CITY OF ALBUQUERQUE

April 2, 2019

RE: **Lot 7 Block 7 Unit 5 S.A.D. 227**
7911 Kibo Rd. NW
Grading and Drainage Plan
Engineers Stamp Date 3/28/19 (E10D060)

RE: **Lot 7 Block 7 SAD 227**
Unser Cliffs
7911 Kibo NW
Grading and Drainage Plan
Engineers Stamp Date 3/28/19 (E10D060)

| | GRADING AND DRAINAGE PLAN | DATE: 3-28-19 |

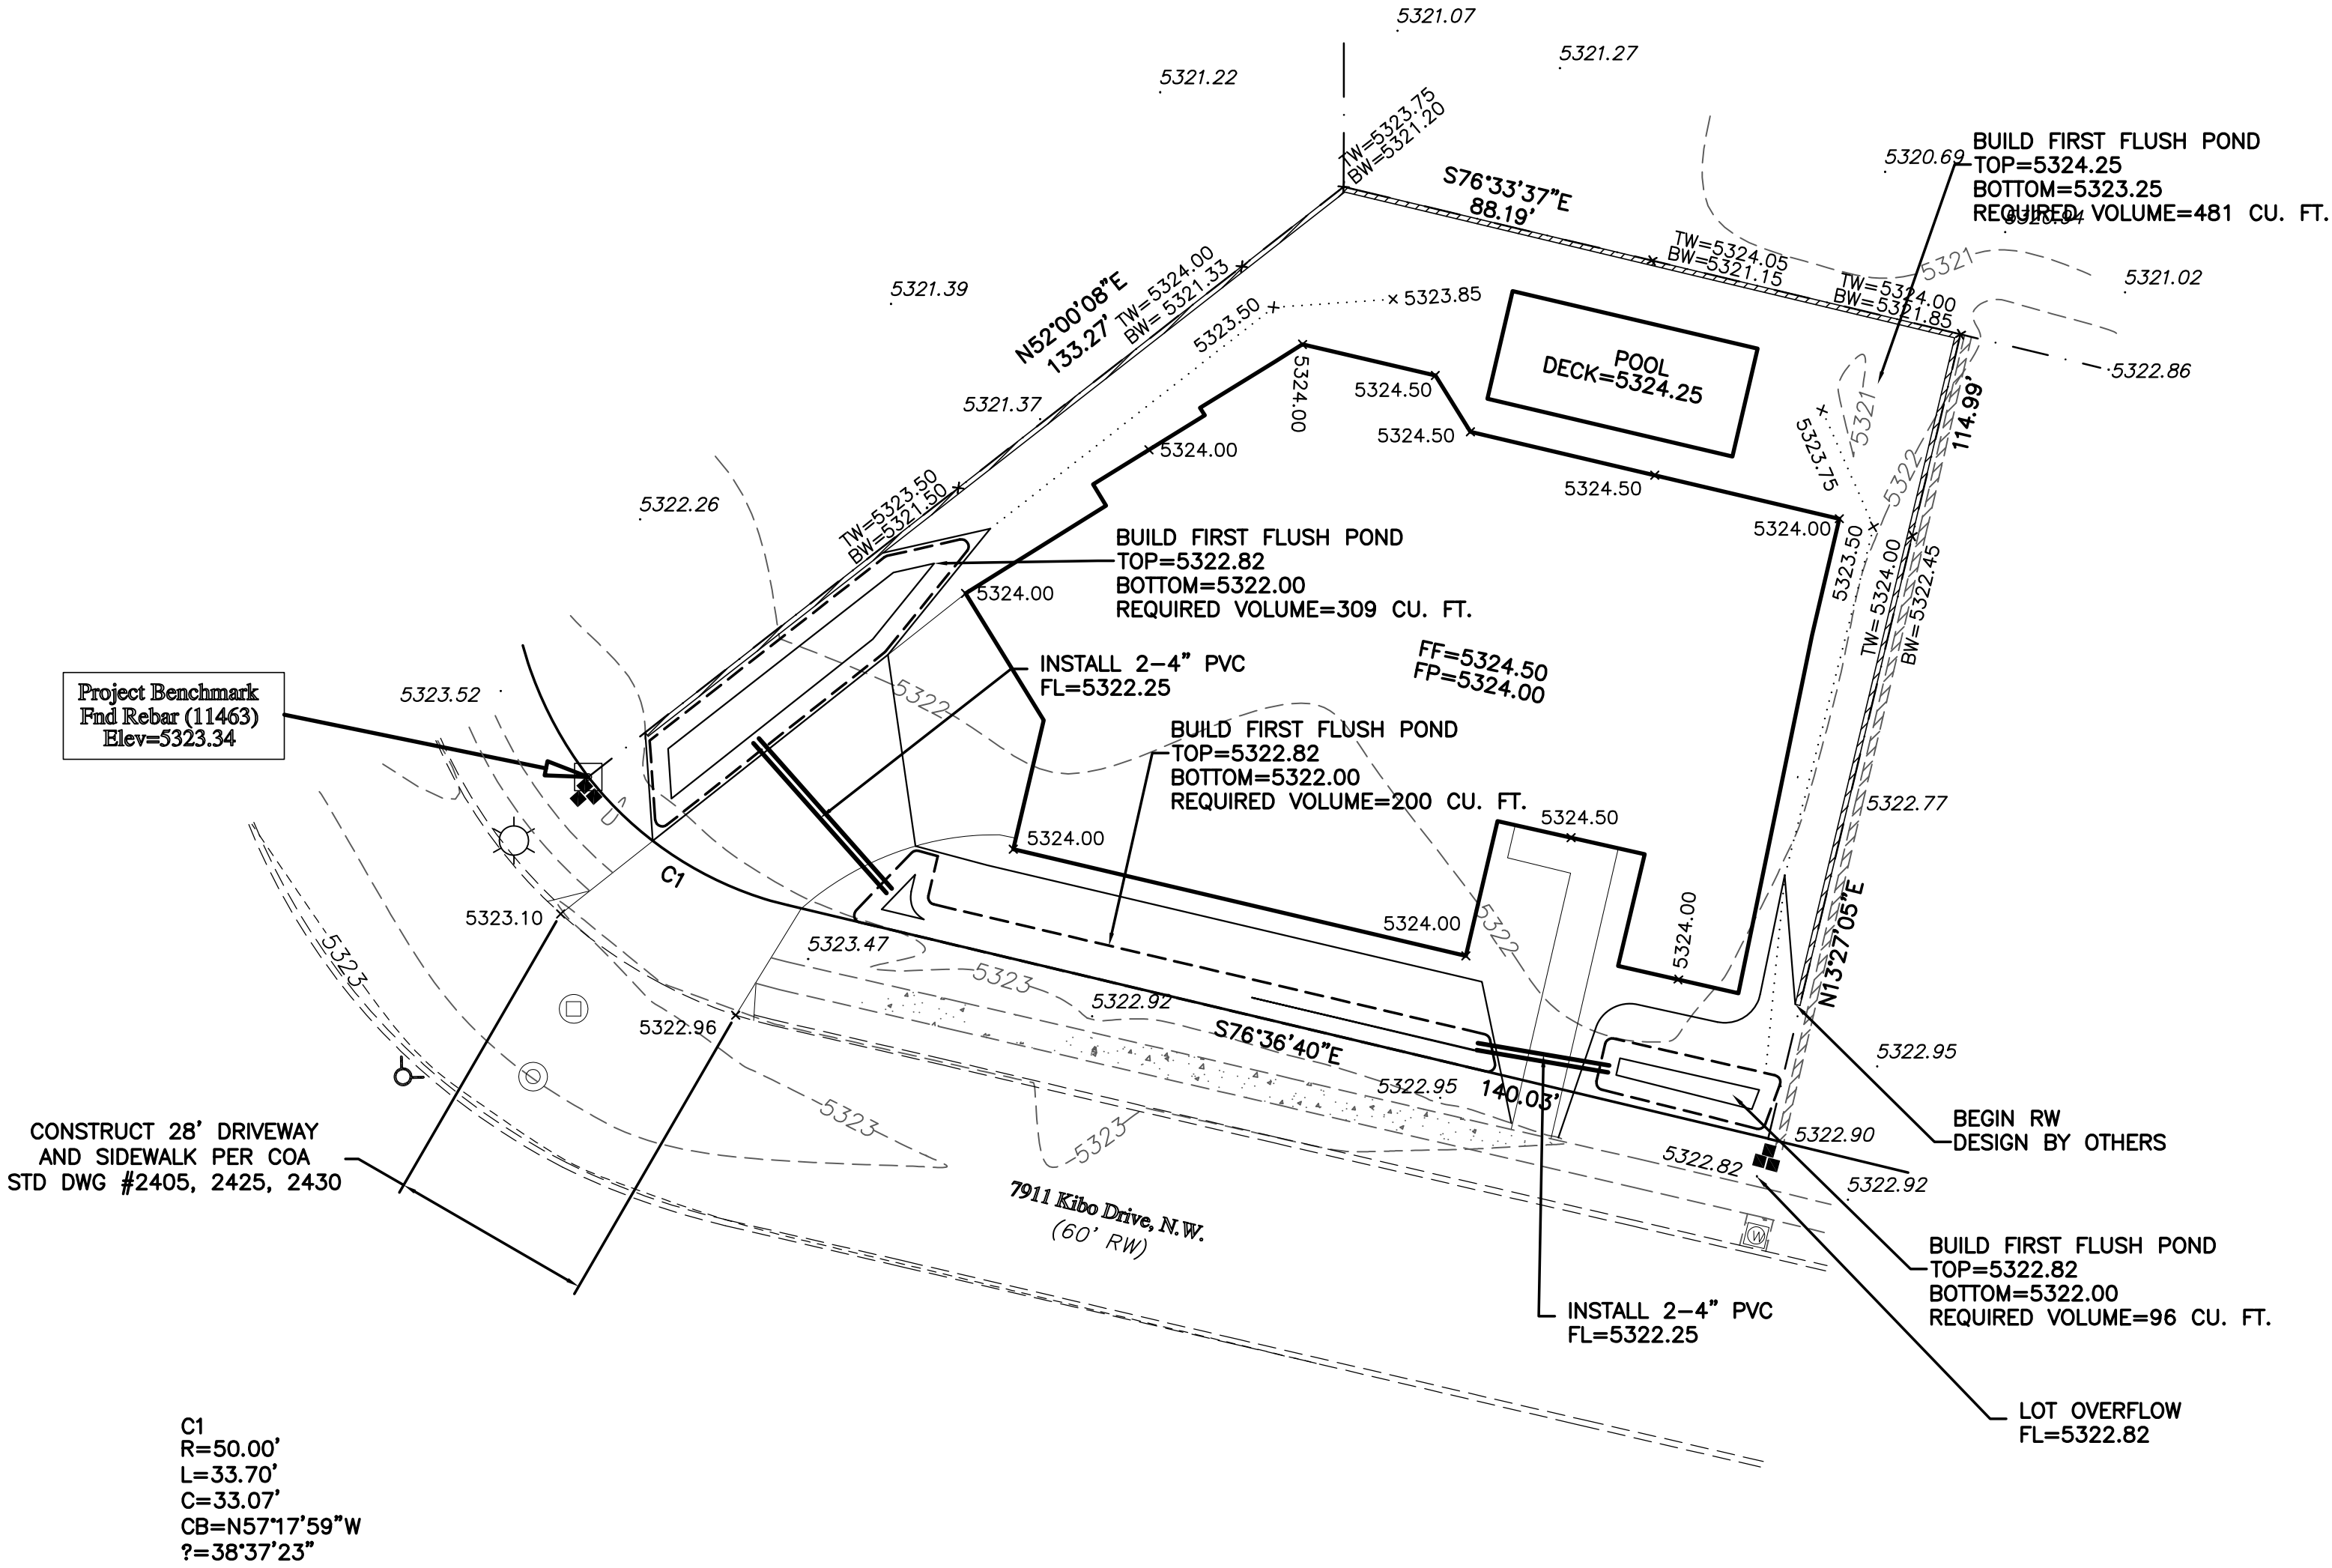
- Provide a detention pond for the site. The percentage required is 34%, the amount of D provided is 58%, the pond must contain the difference which is 24%.

WE HAVE UPDATED THE CALCULATIONS, THE PROPOSED PONDING EXCEEDS REQUIRED
Prior to Building Permit approval a pad certification is required.
